**OXFORDSHIRE COUNTY COUNCIL’S RESPONSE TO CONSULTATION
ON THE FOLLOWING DEVELOPMENT PROPOSAL**

Application no: 22/01715/OUT

Proposal: Erection of up to 500 dwellings with associated access, open space and infrastructure

Location: Land South Of Perdiswell Farm Shipton Road Shipton On Cherwell

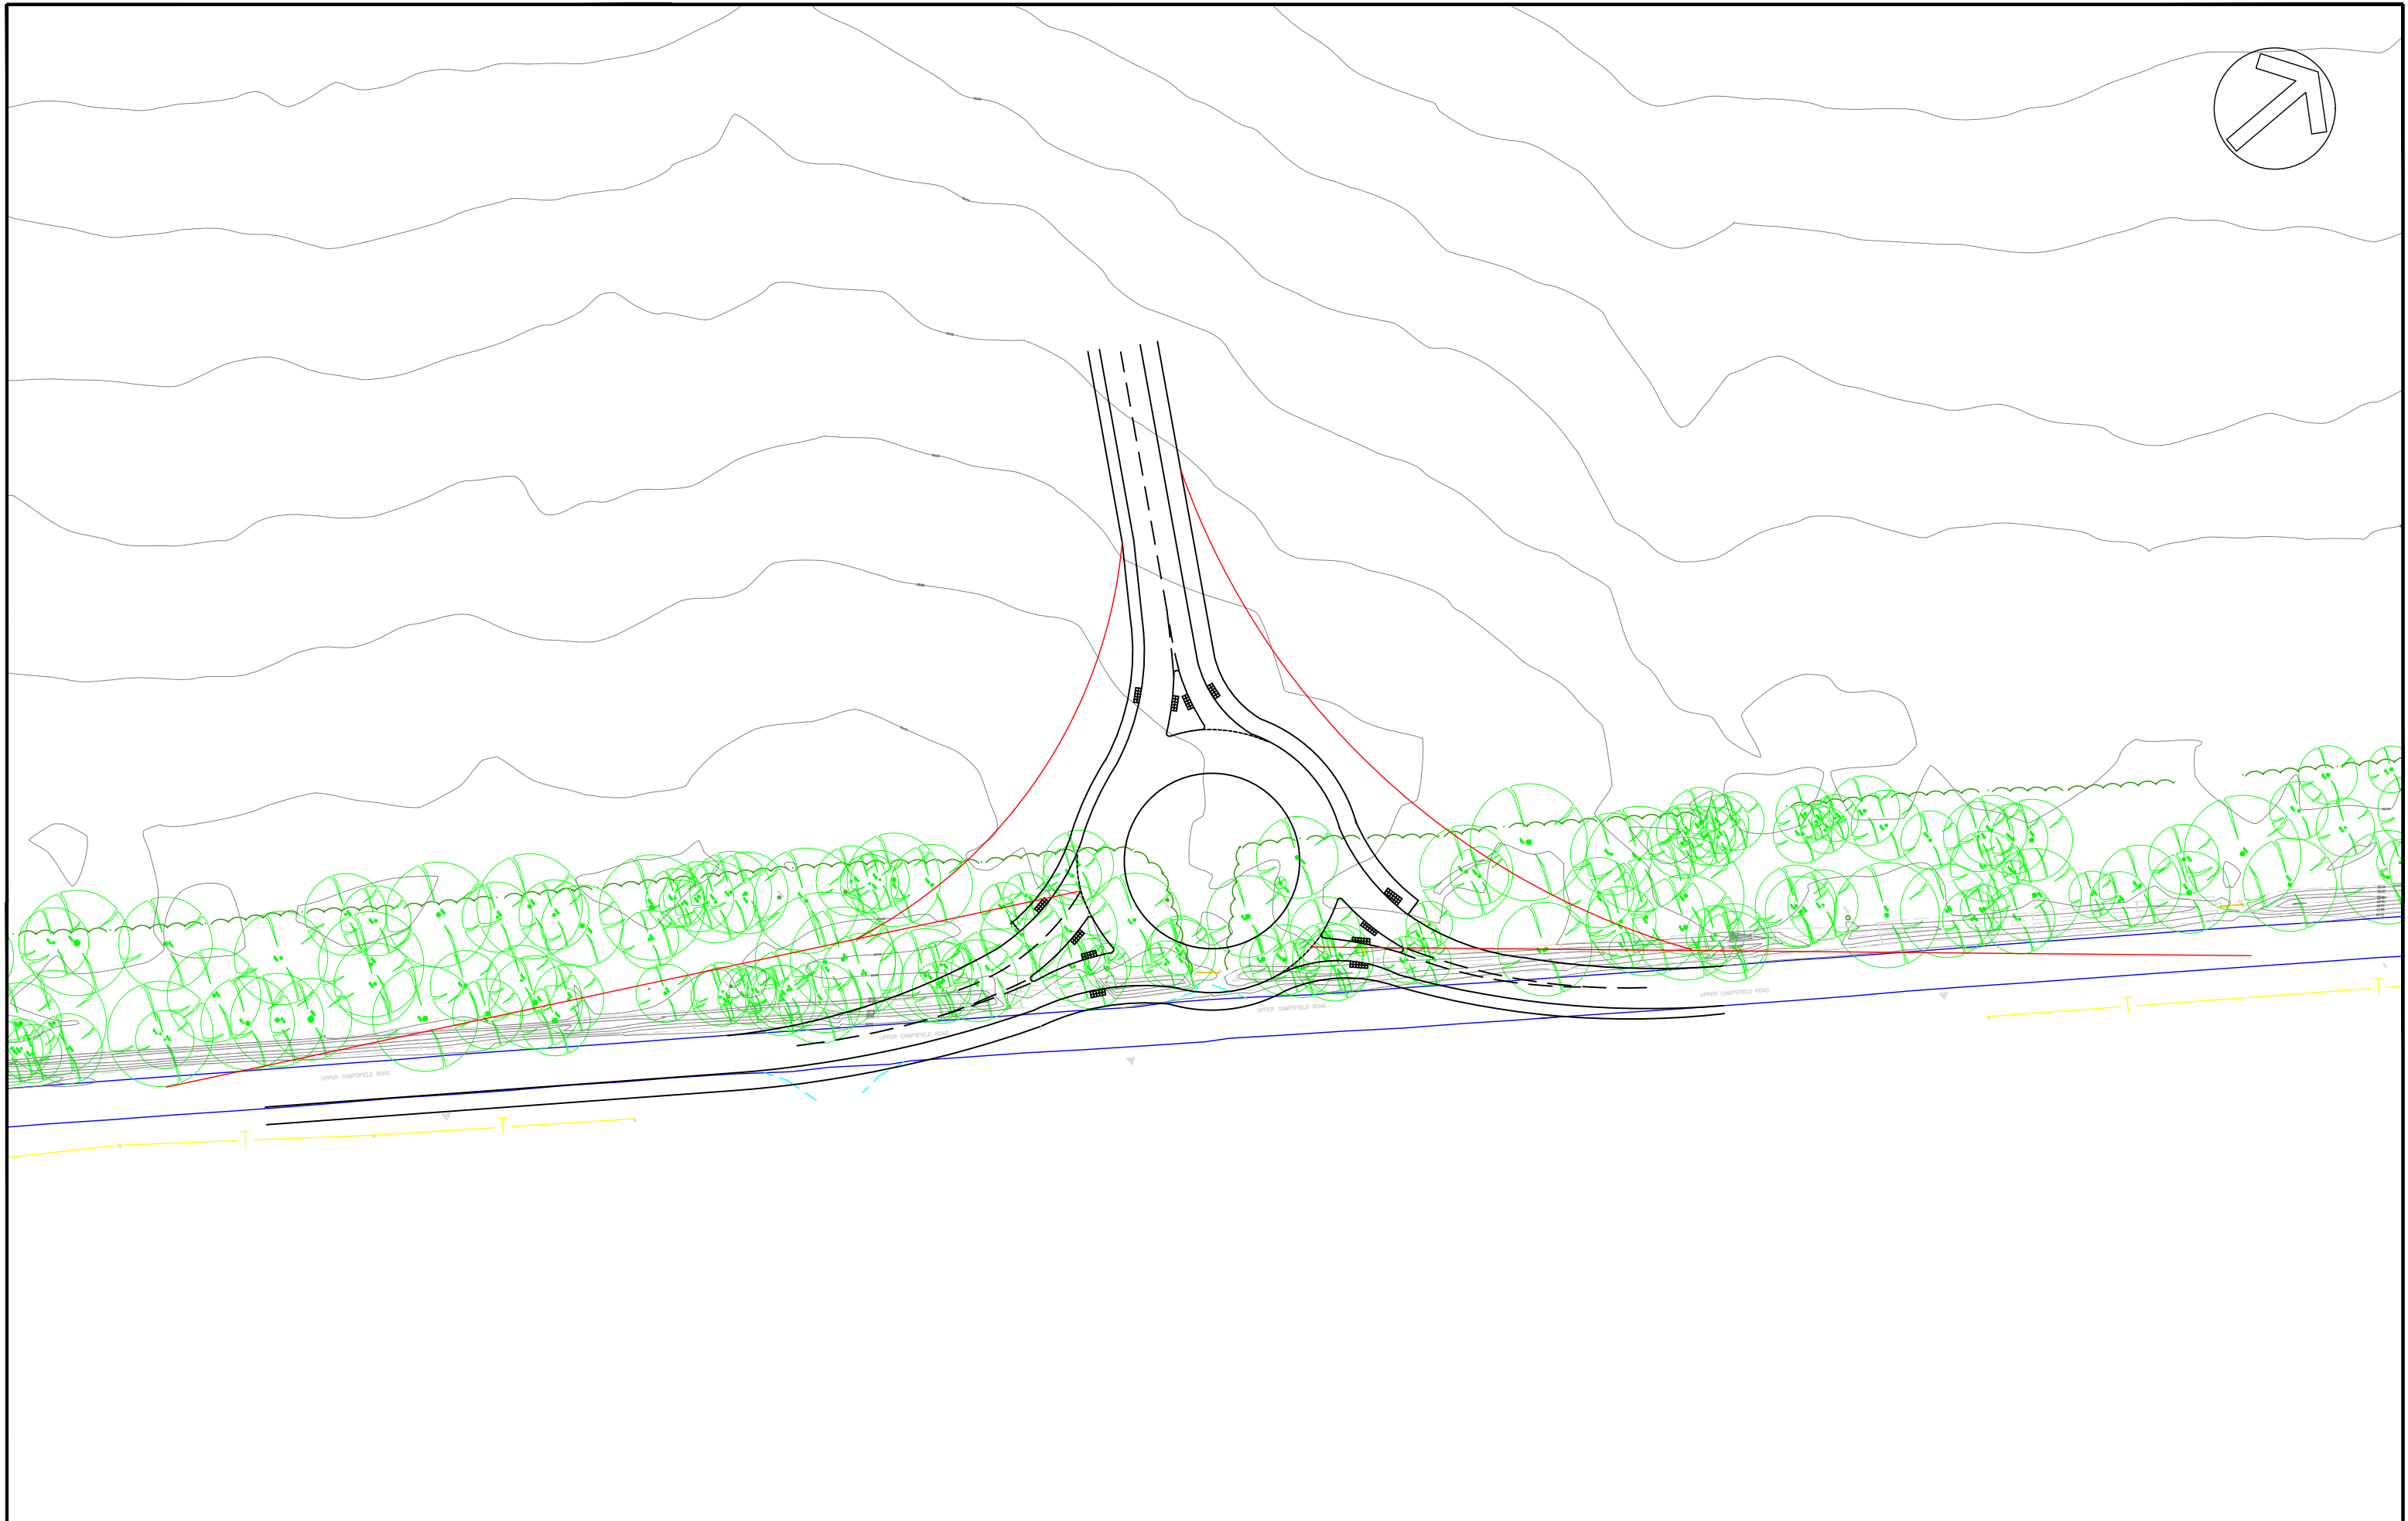
Through a drawing entitled Access Strategy the TAA illustrates how pedestrian and cyclist shall link onto the surrounding infrastructure on their journeys further afield. DTA *Drawing no: 23570-03 GA Rev B* now presents a clearer illustration of how the pedestrian/cycleways from development shall connect onto Bladon roundabout, the A44/Oxford Road and the A4095/ Upper Campsfield Road. The issues that the TAA makes attempt to address or further clarify on are:

- The proposed access junction has now been supported by an acceptable suite of detail including dimensions and tracking exercise. The deflections on all but the western entry appear to be acceptable, however the island may need to shift slightly south to meet the required deflection for the western entry. Given these are new and significant changes to the layout of the highway, a Stage 1 Road Safety Audit will be required. This needs to be submitted at the earliest. **(To be conditioned)**

- Because the siting of the roundabout is not technically audited, it could be that a suitable location for the roundabout is a few metres either end of the current design – to which sufficient land may need to be reserved. **(To be conditioned or agreed as part of the S106 agreement)**

- A new toucan crossing is proposed a few metres to the west of the site access junction. The set back of the crossing from the roundabout is however noted to be off the desire line and will need to be closer to the roundabout. **(To be conditioned)**

The 3m wide shared pedestrian/ cycle route onto the A44 Oxford Road, southwest of the development emerges onto and crosses the A44 Oxford Road by way of an informal crossing. This crossing type is unsuitable for the volume and speed of traffic that pedestrians and cyclists would need to cross at this point. In line with *Policy 1* and *Policy 2* of the *LTCP*. **(To be conditioned or agreed as part of the s106 agreement)**

To include the repositioning of the toucan crossing closer to the roundabout south of the roundabout on A4095 Upper Campsfield Road and the type of crossing on A44 Oxford Road.
